Re: BP#2017-00344 6 City Center - Plan review comments

LIFE SAFETY PLAN

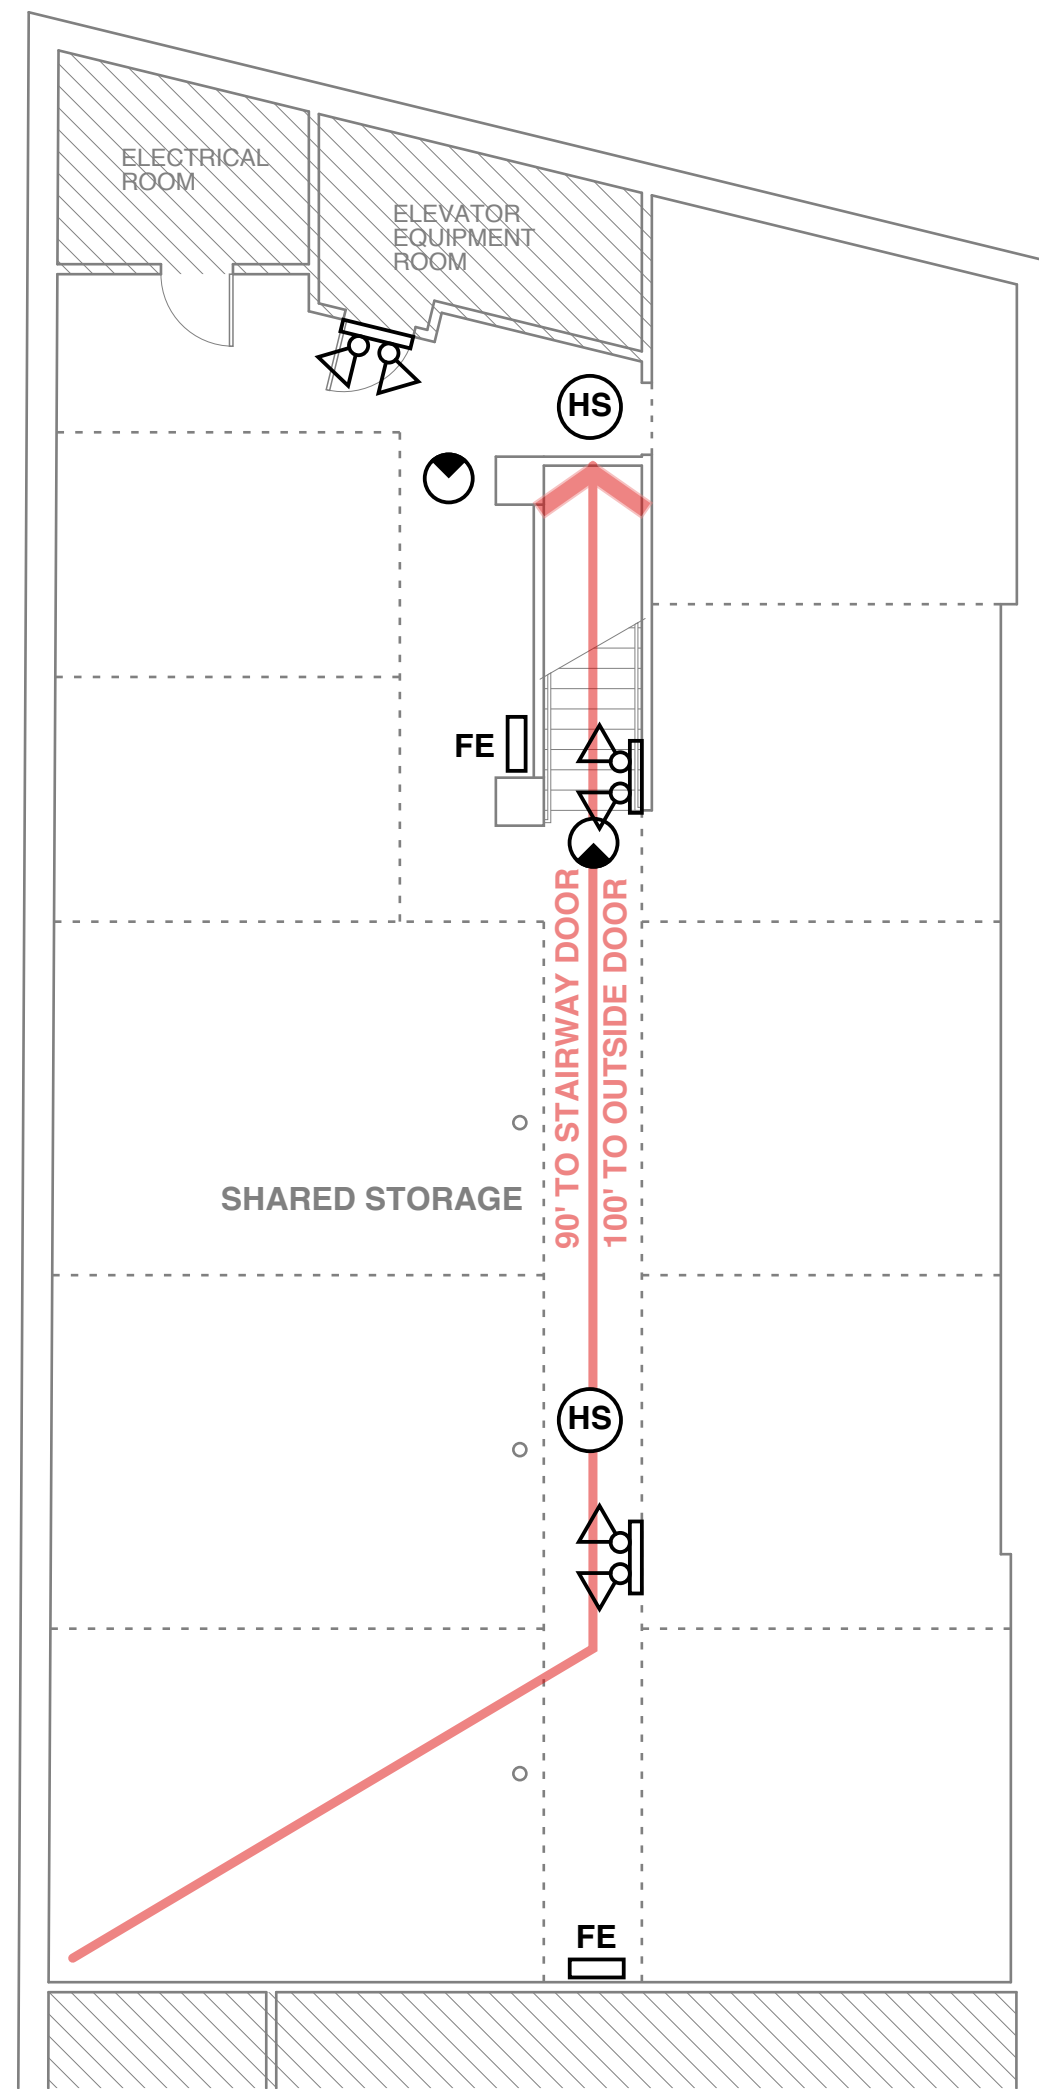
Thank you for your comments. A revised plan is attached. Please note that under IBC 2009, no separation is required between M, B, or S1 occupancies. However, a one-hour separation is required under NFPA 101 2009. I revised both code tables to make that clear.
